Sterling Ranch East, Filing No. 1, SF-22-35

Please accept the following comments from El Paso County Public Health regarding the project referenced above:

TRACT C  
 PROPOSED PRIVATE EXTENDED  
 DETENTION BASIN FACILITY '14A'  
 FULL SPECTRUM DETENTION  
 (EXISTING TEMPORARY DETENTION POND TO SERVE  
 AS A SEDIMENT BASIN DURING CONSTRUCTION)

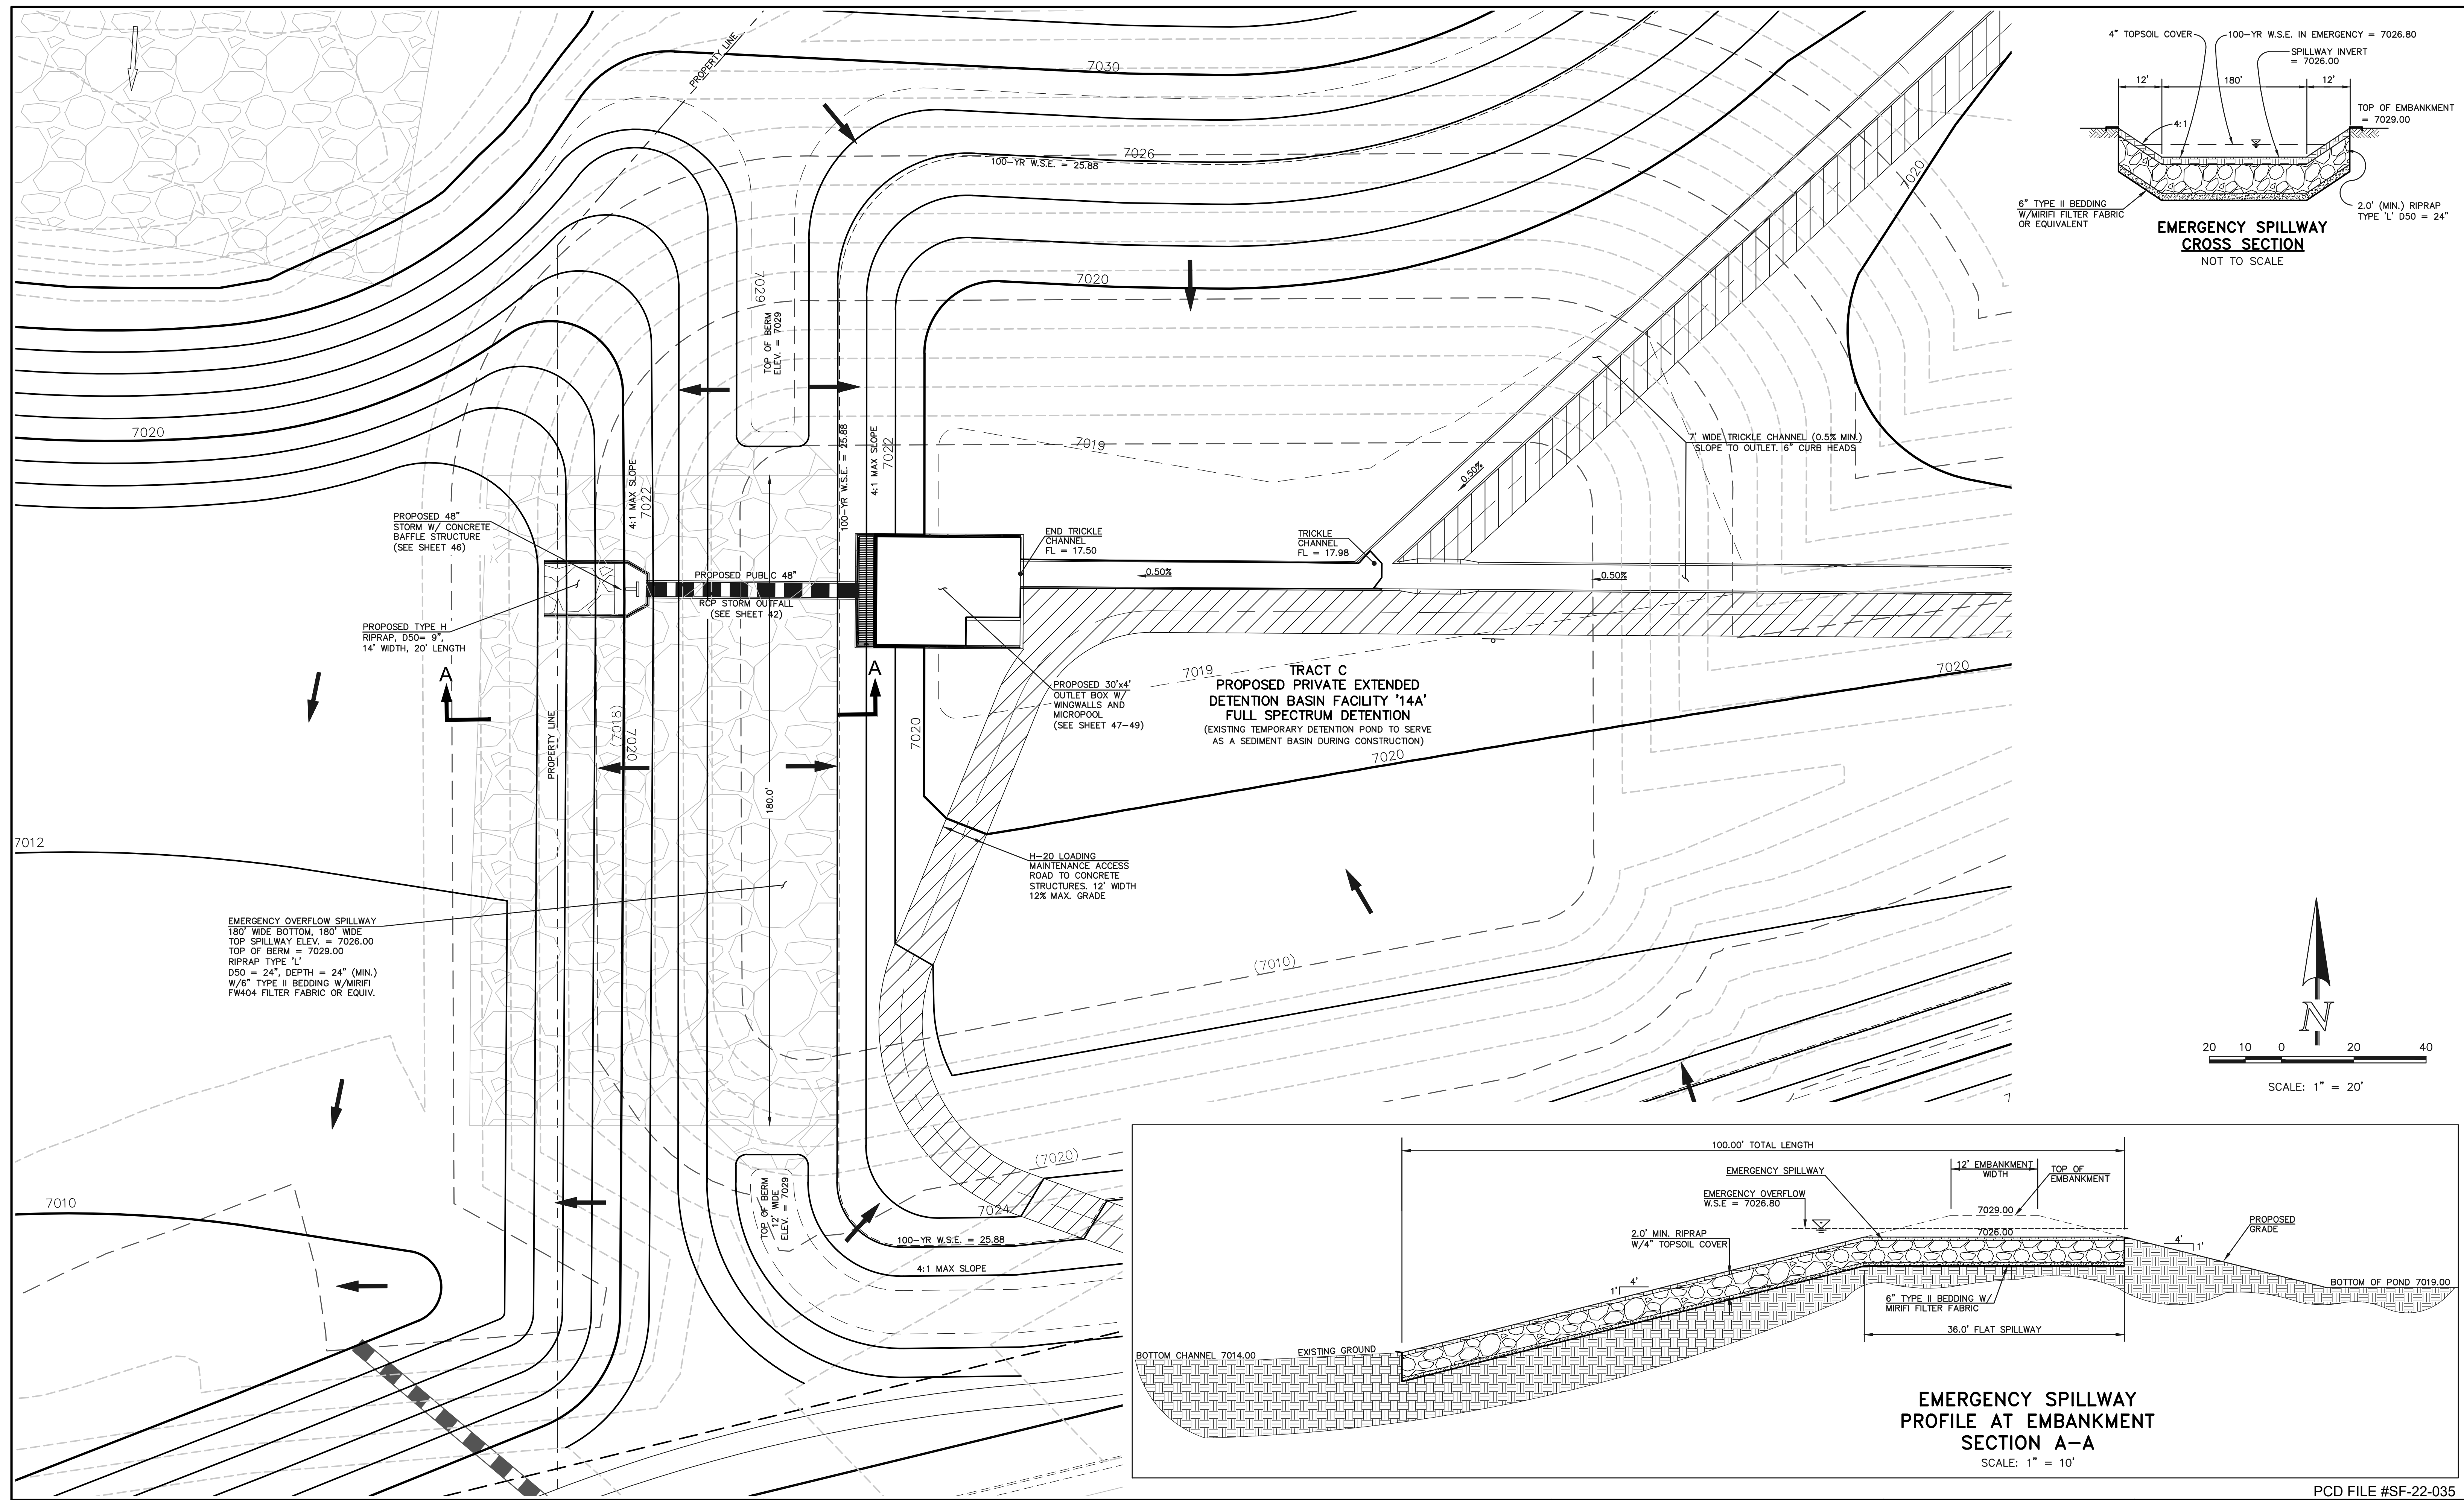
- **The water quality basin in must have mosquito control responsibilities included as a part of the construction design and maintenance plan to help control mosquito breeding habitat and minimize the potential for West Nile Virus.**
